DAILY FIELD REPORT

Date: 12/2/10
Project: 62 Cumberland Ave 3-Unit
Project #: 14472
Site Contacts: Mike White - Island Carpentry
Purpose of Visit: Rebar inspection and concrete testing services.

**H1** FOUNDATION PLAN 1/4" = 1'-0"

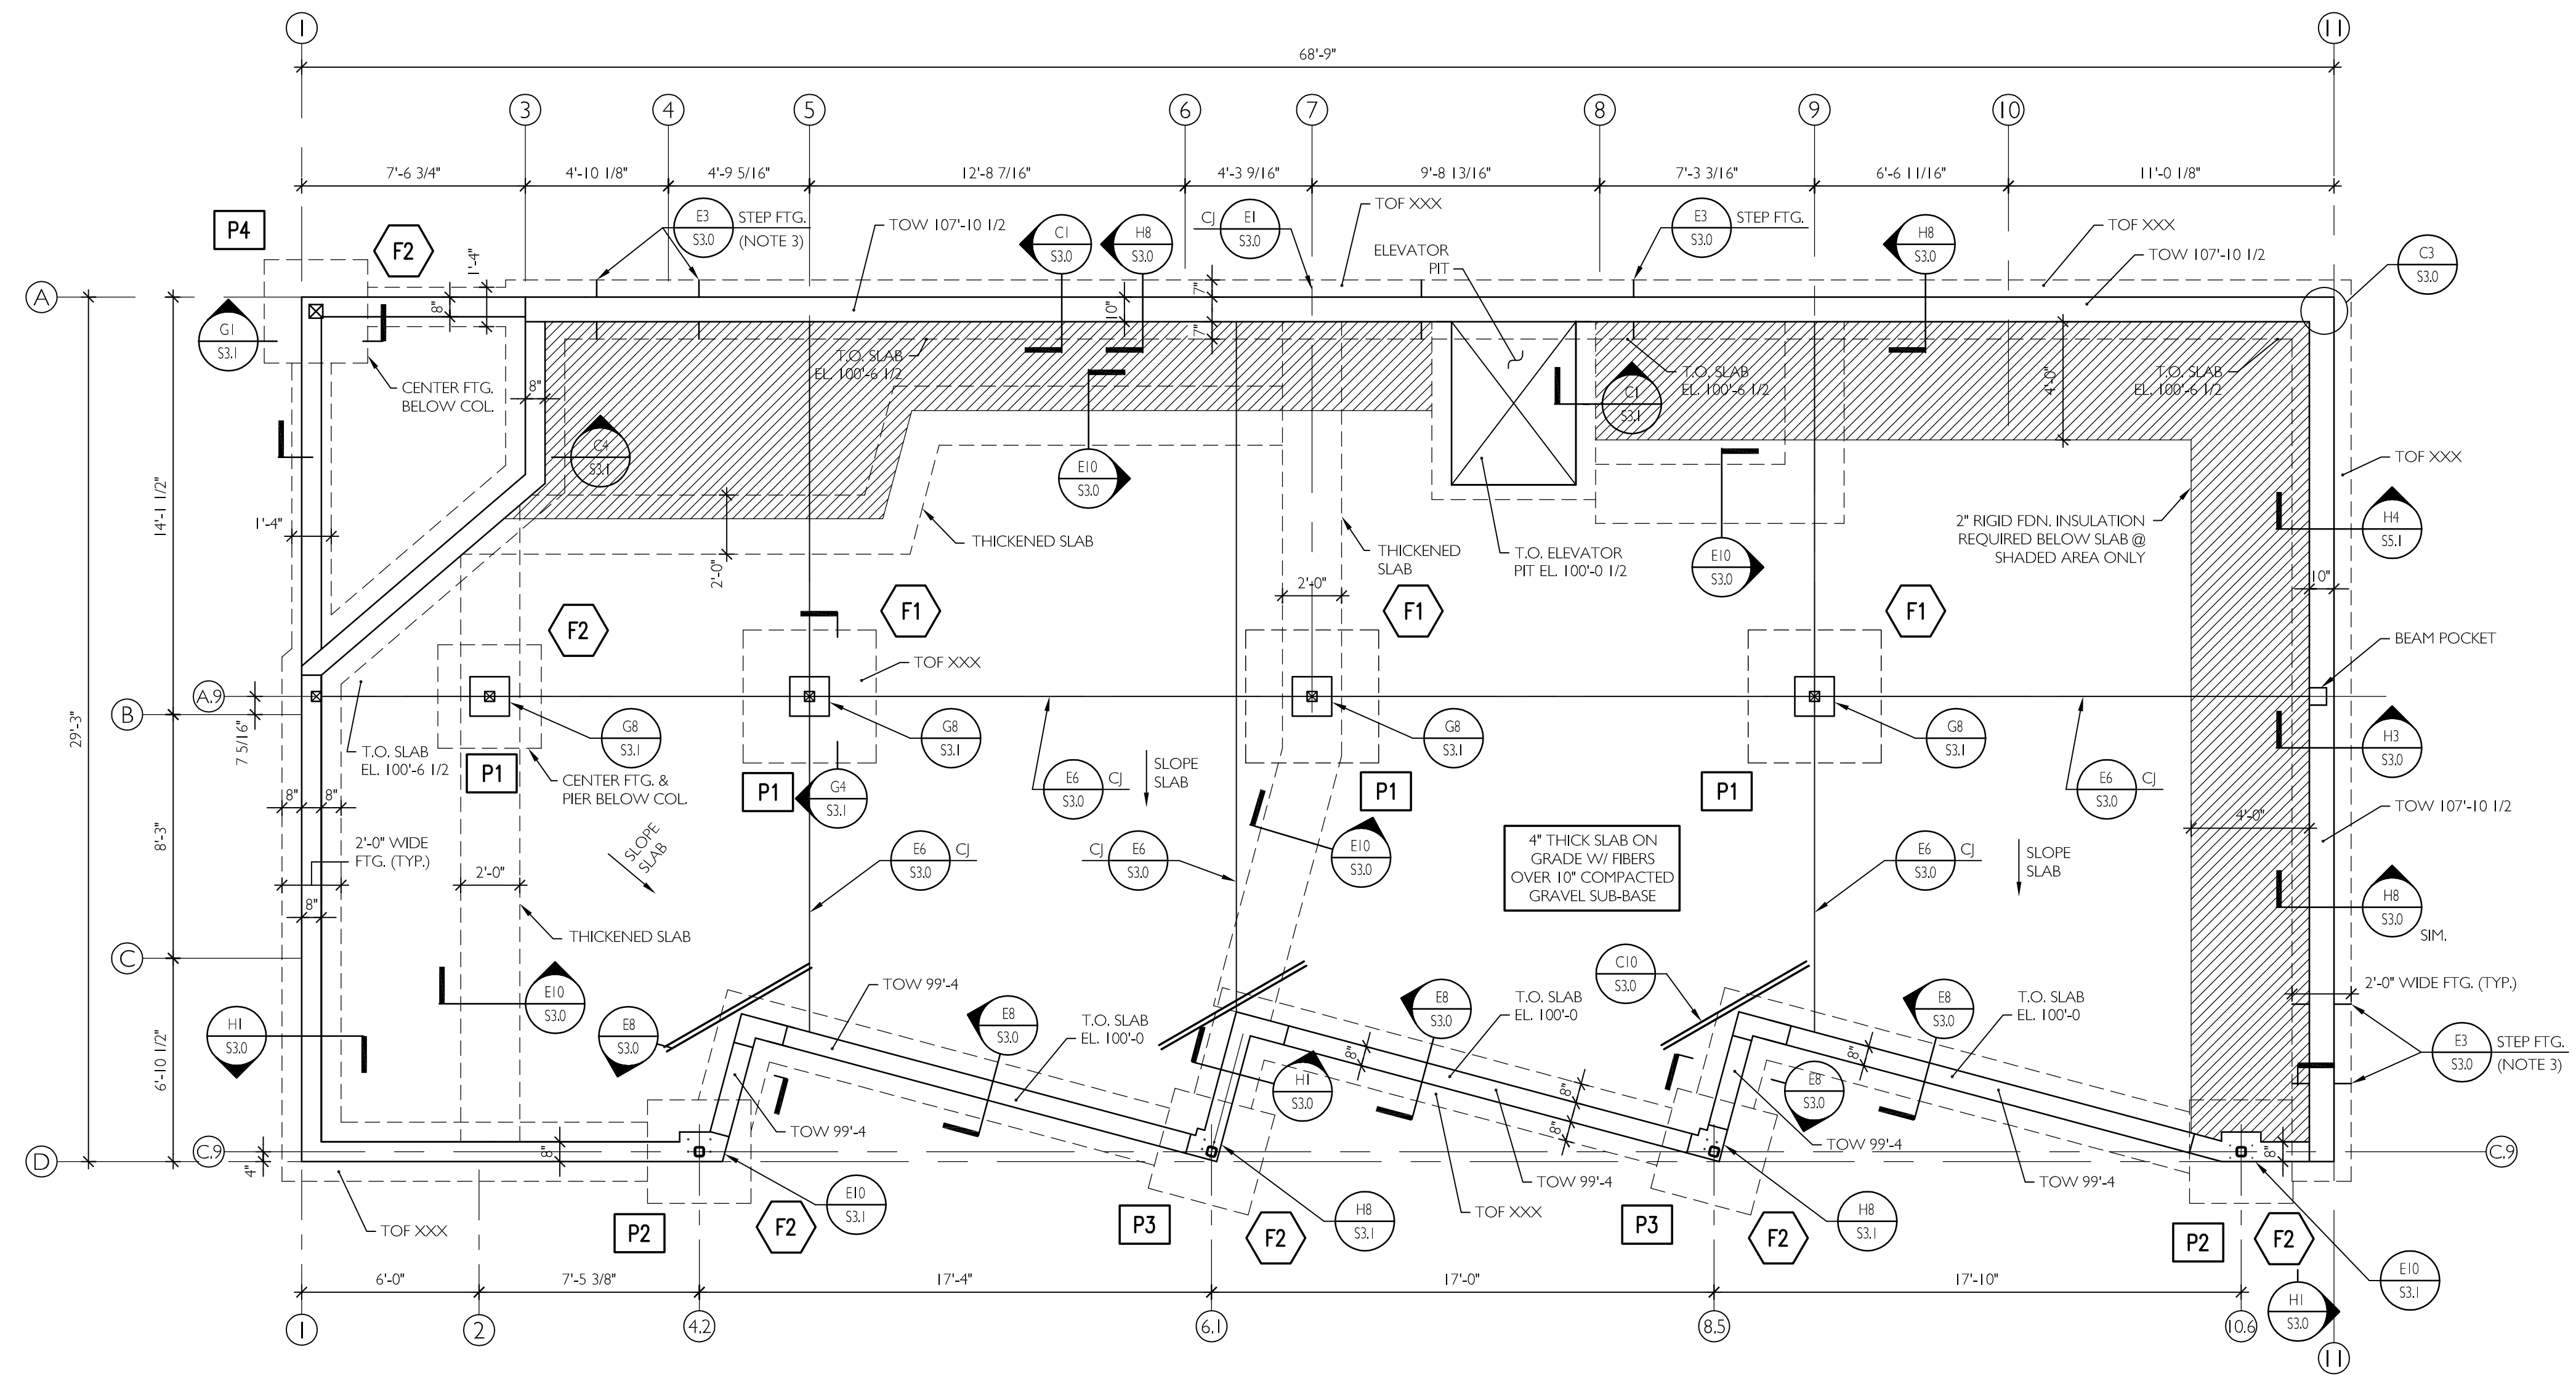
- All bar sizes were consistent with plans and specifications.
- Steel did not meet clearance specifications in all areas.
 - Endwall at line 11 at line C.9
- Spacing of reinforcement met requirements
- There were several areas where lap/splice lengths did not meet the minimum requirements of specifications:
 - Line 3.5 to 4 at line A
 - Line 4.5 at line D
 - Line 3 at line A.4
 - Line 1 at line C.9
 - Line 11 at line C.9
- There were several instances of steel reinforcement not placed according to specifications at all corners and an endwall.
- There was an excess of form release oil used inside the forms, which is shown in the attached pictures as the blue colored pools on the footings.

**C3**  
TYPICAL DETAILS AT WALL CORNERS AND INTERSECTIONS  
S3.0 NTS

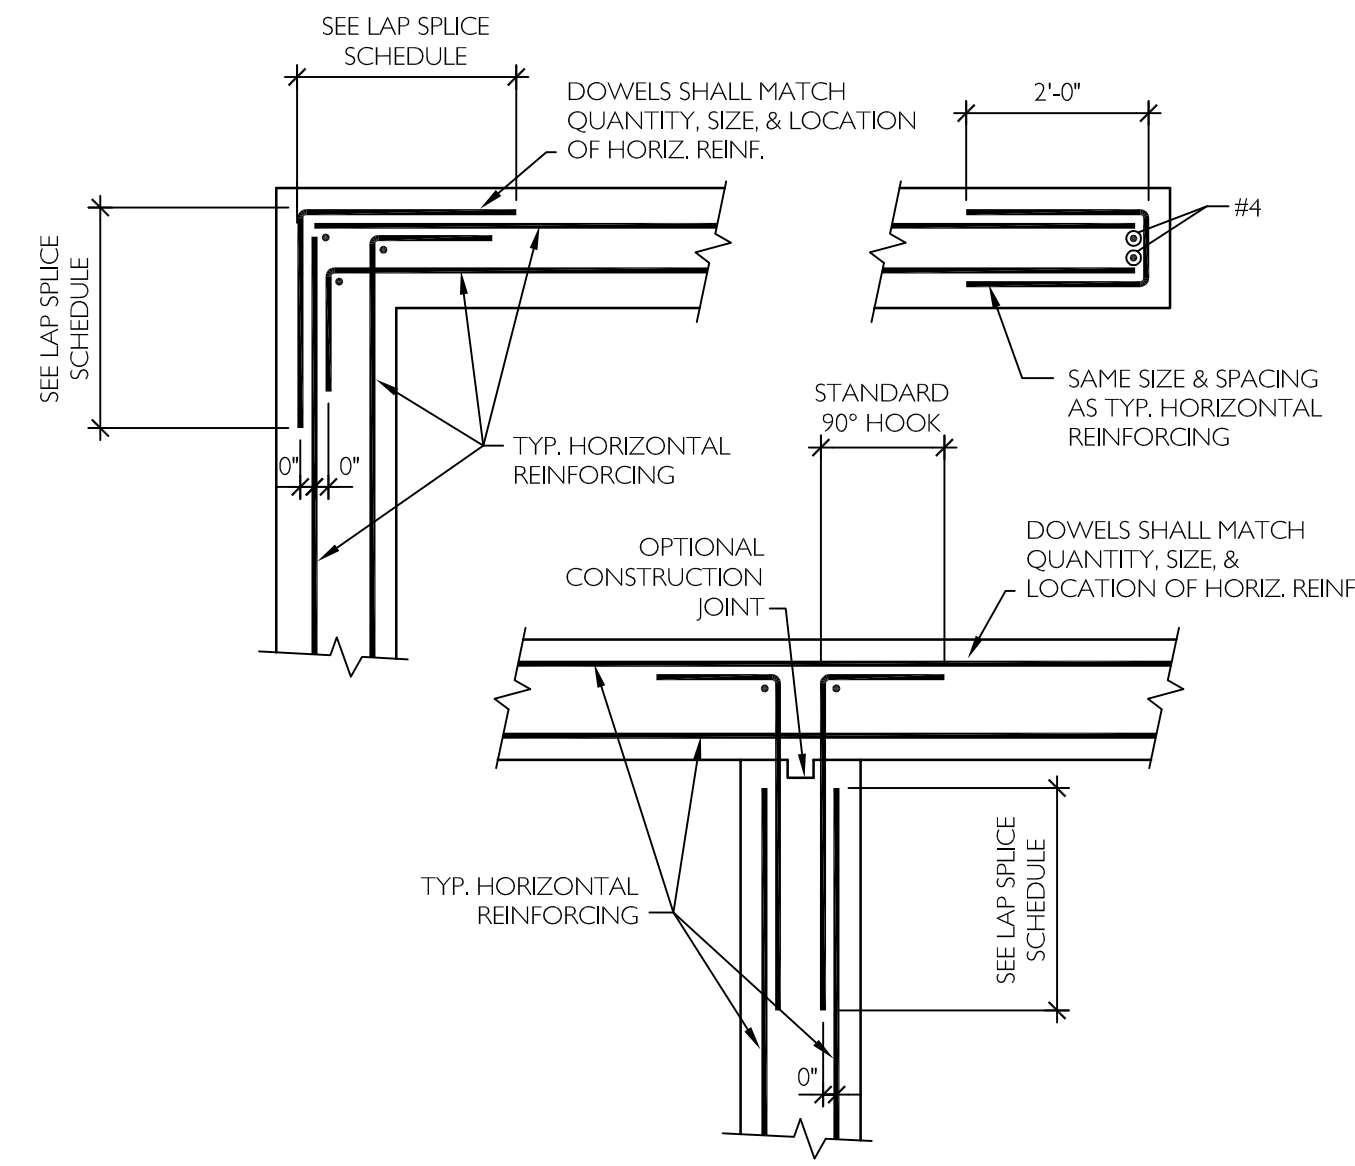
- 1) Upper horizontal reinforcement in all foundation walls
- 2) Bondout in foundation wall at Line A, Line 9 to Line 11 (see H4/S3.1)
- 3) Break in horizontal reinforcement for control joint at Lines A and 7 (see E1/S3.0)
- 4) All vertical reinforcement at wall corners and at ends of walls (see C3/S3.0)
- 5) All #4 bent bars to connect top of wall to slabs (see E8/S3.0)
- 6) Verify piers at garage entrances reworked to include 4 horizontal stirrups and 4-inch clearance off footers (see E8/S3.0 and C4/S3.1)
- 7) All anchor bolts

Vertical bar placed at interior of corner, inconsistent with C3/S3.0
Missing upper and lower horizontal interior and exterior bar laps.

Upper endwall horizontal and lower horizontal and vertical corner bars placement inconsistent with C3/S3.0

Corner vertical and horizontal bars placement inconsistent with plan. C3/S3.0

Endwall vertical and horizontal bars placement inconsistent with plan. C3/S3.0
Upper horizontal bars did not meet lap requirement per E.9/S1.0 (Ruler in picture overexposed due to flash.)
Bars at endwall were held away from forms during placement. Exterior upper horizontal bar did not meet clearance specification.

**E1**  
TYPICAL FOUNDATION WALL CONTROL JOINT (CJ)  
S3.0 NTS

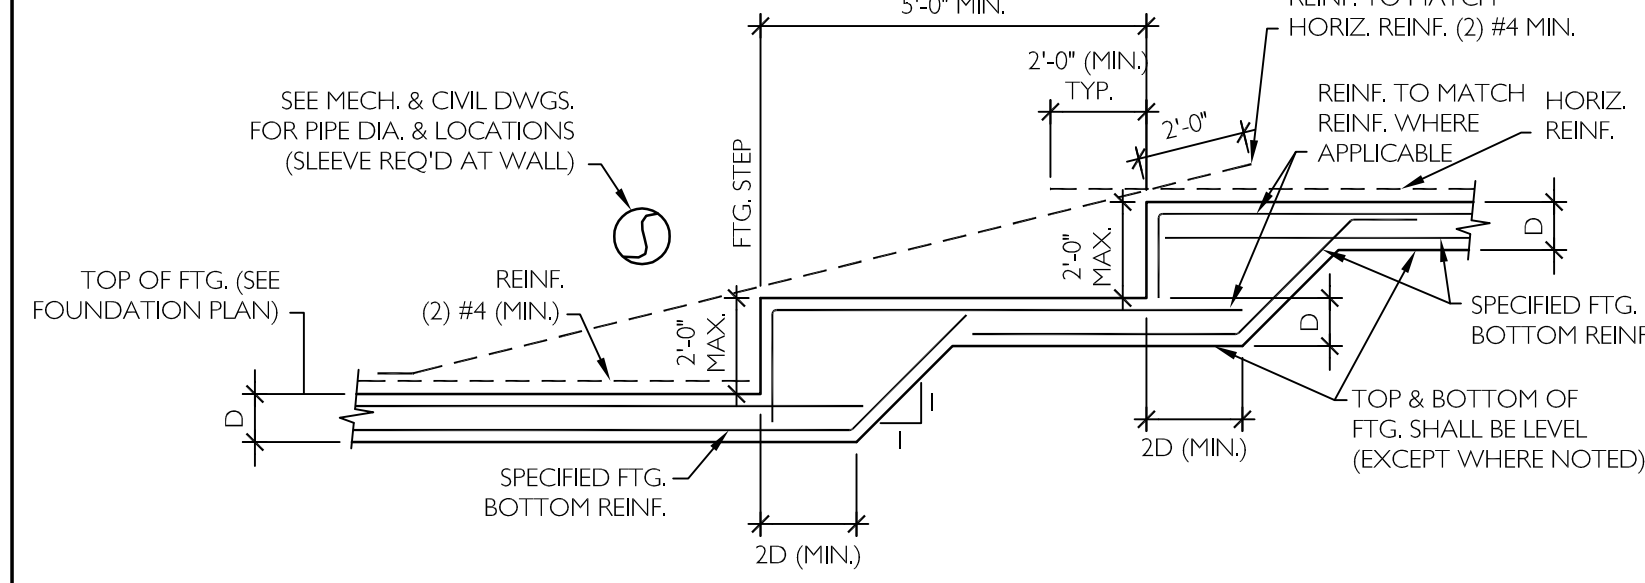
2 inch gap cut out of exterior horizontal bar per E1/S3.0 (Control joint)
